# PORTLAND MAINE

March 24, 2011

I assigned Shukria Wiar, Planner, to project manage the site plan review of the seasonal outdoor seating area for Bowl Portland. David Matero will receive an e-mail from the Department to upload the plans and documents to a designated web site for review by City staff and consultants.

RE: Bayside Bowl

FD.1
Level 1 Site
Plan Alteration

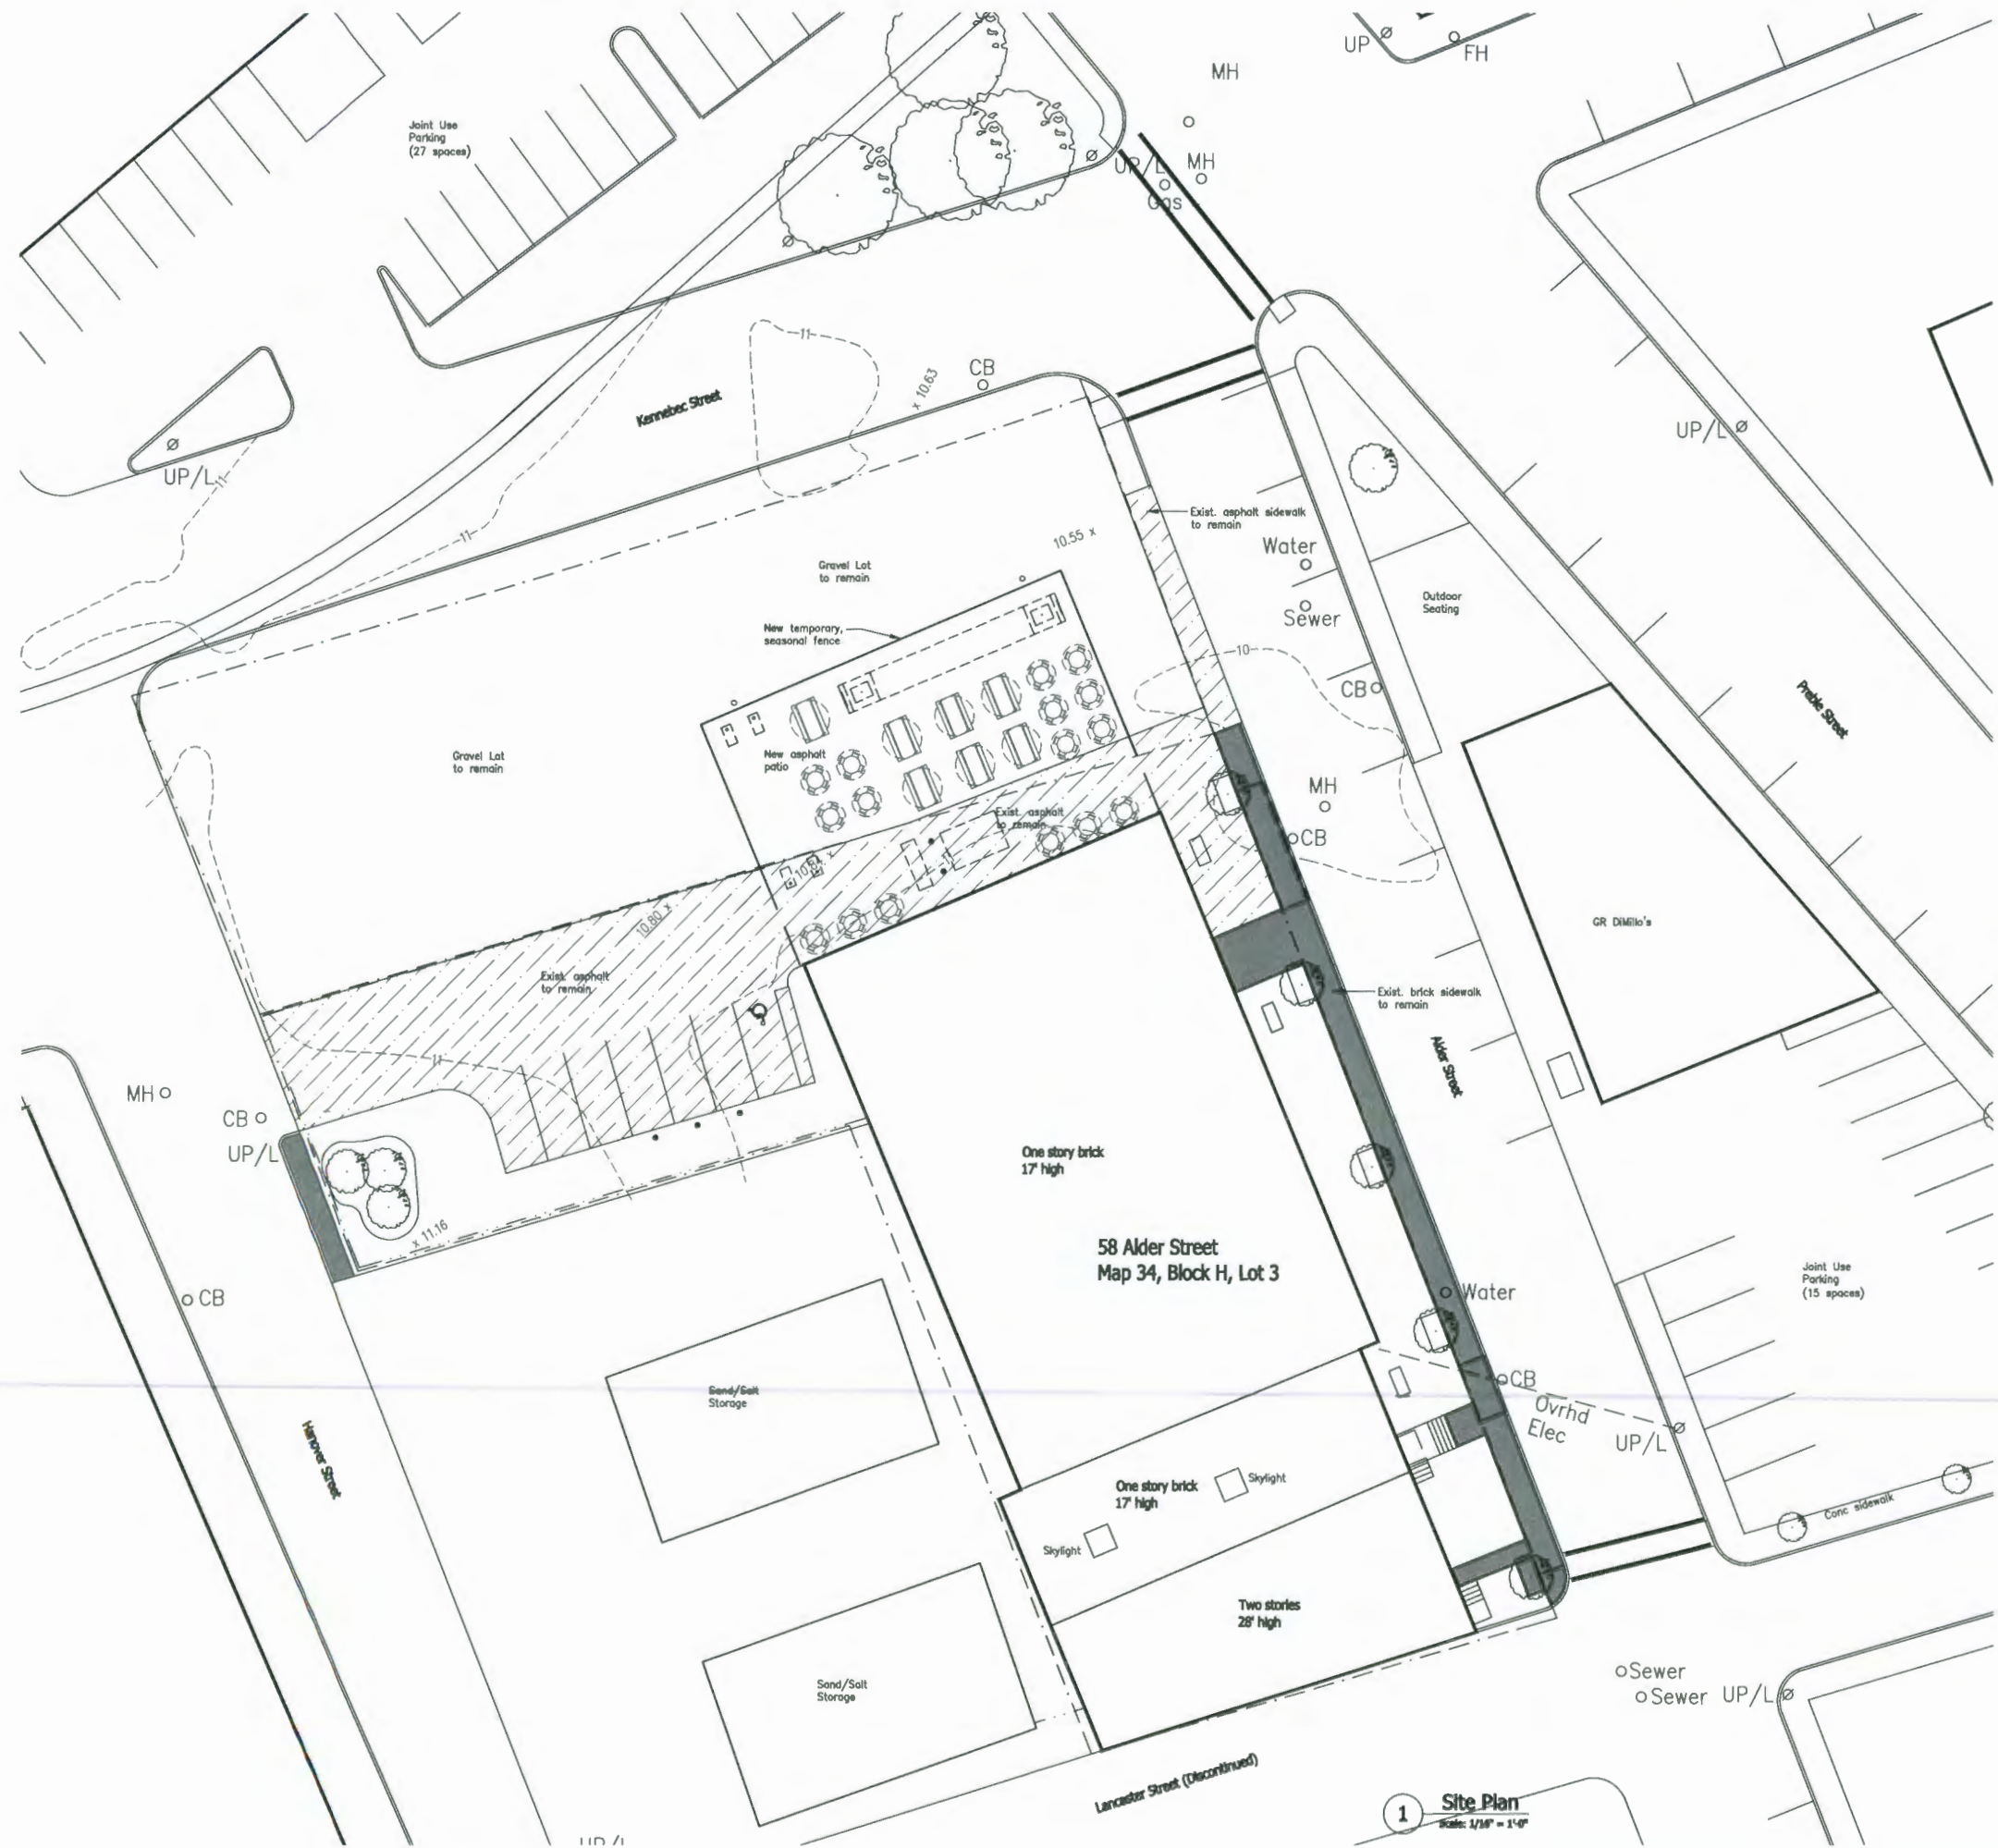
1. Traffic generation and parking demand analysis should be updated.
2. The TDM should be updated.
3. Utilities should be shown on the plan.
4. A survey should be submitted with the plan.

5. What is the ground surface of the outdoor facility? Will the site be regraded and if so, how will it affect drainage?
6. The property is a separate lot from the existing facility so new curb and sidewalk will be required along the property's street frontage on Alder Street and Hanover Street. The street frontage along Kennebec Street is likely to be discontinued under a proposed re-alignment of Kennebec Street and Somerset Street. In lieu of installing sidewalk and curb along Kennebec Street, it may make sense to require a financial contribution to the re-alignment (in the amount of the curb and sidewalk) for the City to install later.

7. I noticed there are new parking spaces shown on the plan. Under the existing ordinance, new surface parking is not allowed within 35 feet of the street. New parking more than 35 feet from the street requires Planning Board conditional use review. We are working on some new zoning revisions that would allow parking more than 35 feet from the street as a permitted use.

8. The proposed 6 foot high fence seems high. In the context of Bayside the design of the fence will be important.

9. It appears this proposal qualifies for site plan review with staff review assuming no new parking spaces are created (see #7 above).
10. The submission requirements for a site plan are outlined in the ordinance.
11. If outdoor music is proposed noise is regulated under the zoning ordinance [sec. 14-299 (b)].

Thank you for submitting an administrative authorization application for 58 Alder Street. I reviewed the application and have determined that the proposal triggers a Level I Site Alteration review under provision 14-523 (d) 2 c of the Site Plan Ordinance:

The amount of area to be paved is not shown on the site plan, but I estimate that it is roughly 2,560 square feet of impervious surface area. Enclosed please find your check for the administrative authorization, which is being returned, and a copy of the Level I application for your use.

- Evidence of Right, Title and Interest;
- Confirmation that the seating area is not a parking lot, nor will be used as a parking lot following approval as a patio area.. Please note the Planning Board is holding a public hearing on proposed amendments to the B-7 zone to allow some surface parking lots as a permitted use on Tuesday, March 8th. As drafted, the changes may not impact your proposal, but you may want to discuss the pending amendments with Rick Knowland or attend the meetings. Please let us know if you would like to be placed on our interested party list so you receive notice of when the Planning Board or City Council will be considering the B-7 amendments;
- Address closing off the curb cut with curb and sidewalk along Alder Street;
- Provide a plan for the management of storm water on the site and show the contours or spot elevations for the re-grading of the site;

- Address any proposed landscaping and the details of the fencing, including whether the fencing is permanent or temporary and any separation needed between the seating and 7 space parking area:
- An expanded project description would be helpful, such as the proposed hours of operation, proposed time frame for this seasonal use, the proposed uses for the area, including whether outside music is proposed, will food be prepared outside and where and how will the equipment be stored during off-season. (If the site will be used for off-season storage of equipment and fencing, please provide a winter conditions plan.)
- The traffic engineer will review the TDM as part of the Level I review, so there are no preliminary comments at this time.
